Ouse & Derwent Internal Drainage Board's Response to the Examining Authority's written questions and requests for information (ExQ1) issued on 22 September 2026 – Light Valley Solar Project

LIGHT VALLEY SOLAR
Figure 12.01
Light Valley Solar - Site 1
Outline Environmental Masterplan- v3.0
[EN0110012/APP/LVS/02.12.01]

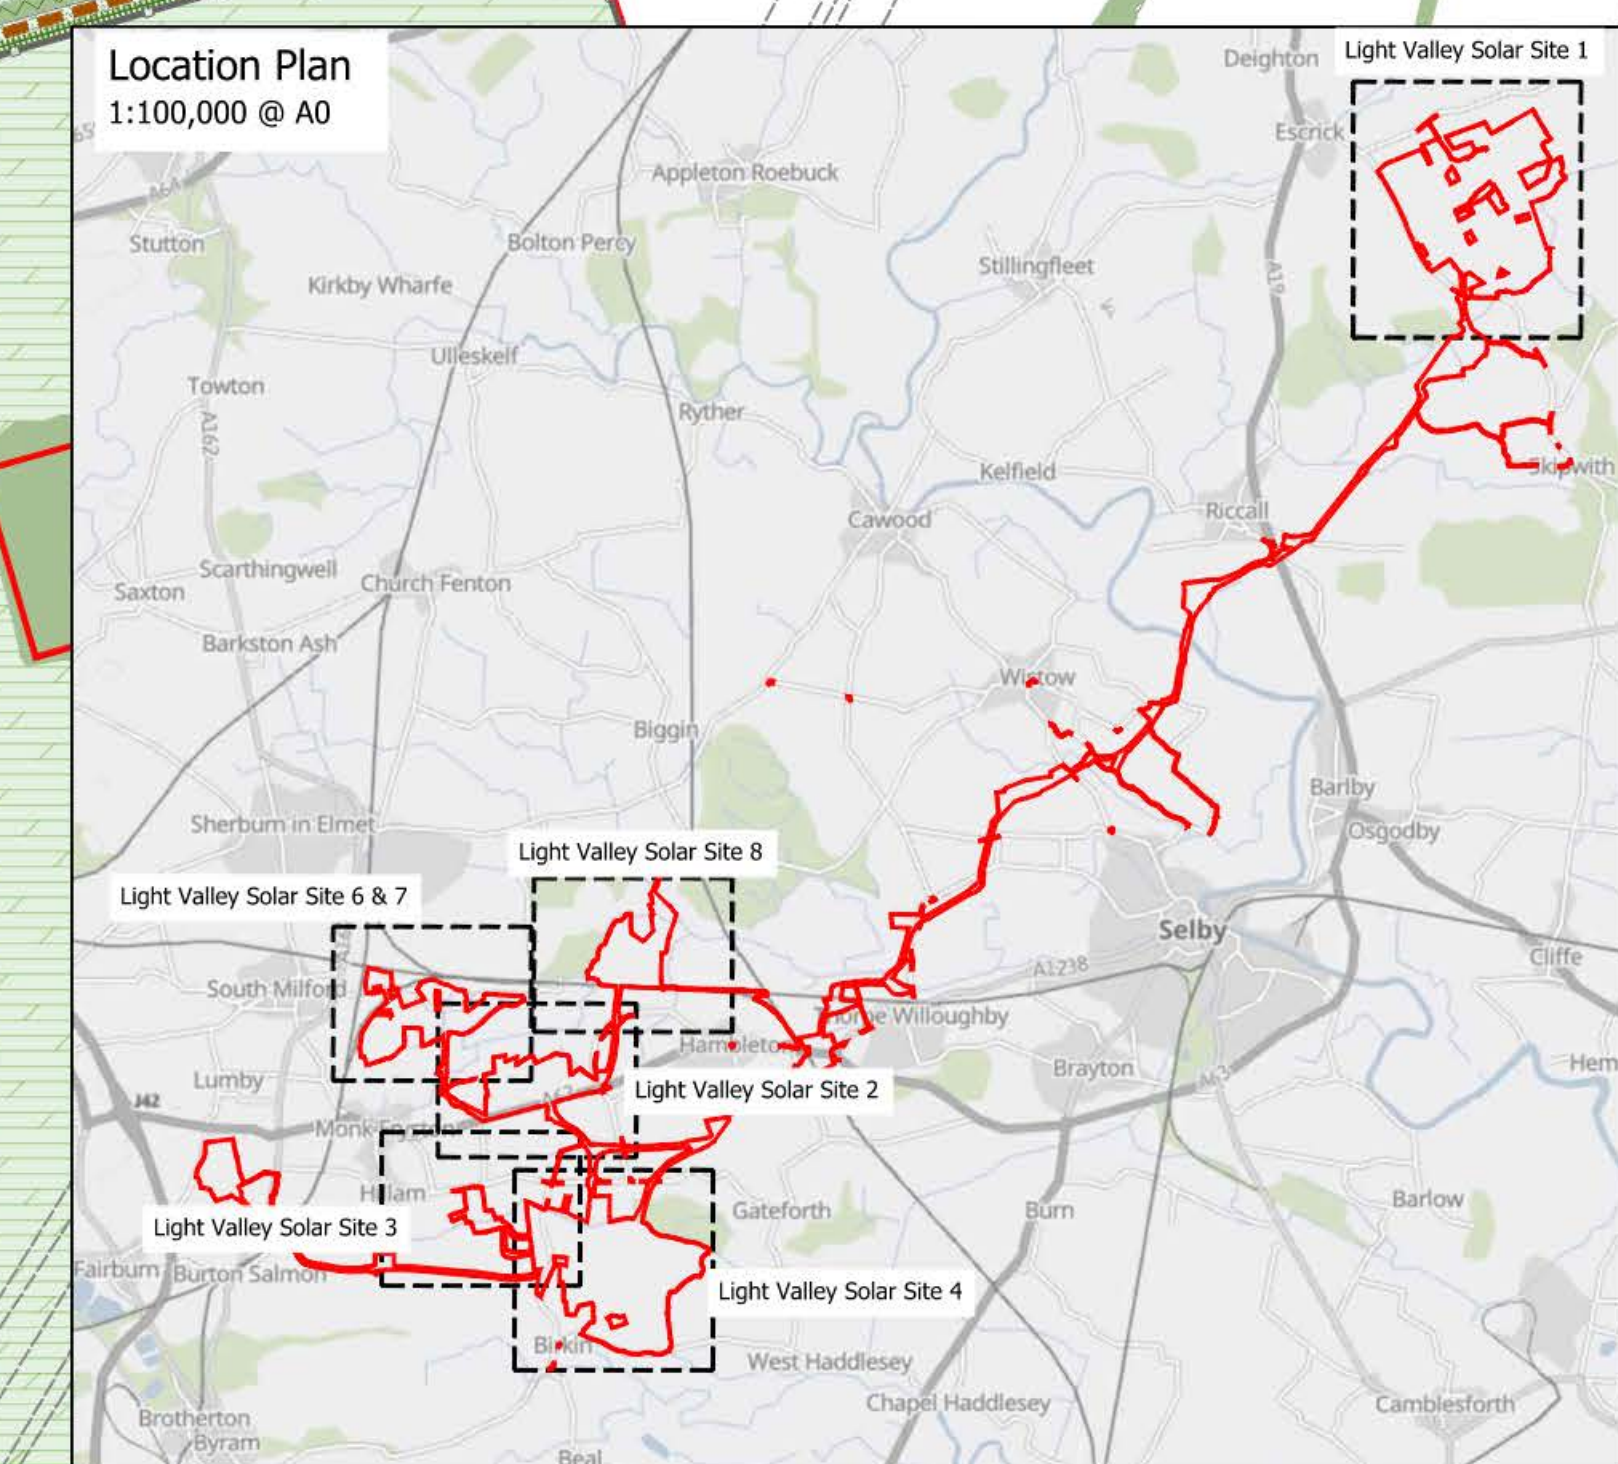
Q1.15.13	Planting near watercourses The updated DPC [REP2-021] submitted at deadline 2 states that “planting within the 10m buffer of Ouse and Derwent IDB watercourses will only be on one side of the watercourses and will be on the side that the IDB don't work from”. Parties are to provide a view whether the same, or similar, commitment should be made for all other watercourses?	The IDB were able to agree this on this specific site based on the size of the watercourses and what we have historically agreed with the landowners surrounding the watercourses on Site 1 specifically. However, this is not something we could agree on every watercourse in our district – we sometimes have to work on both sides. This agreement with the applicant was very much specific to Site 1.
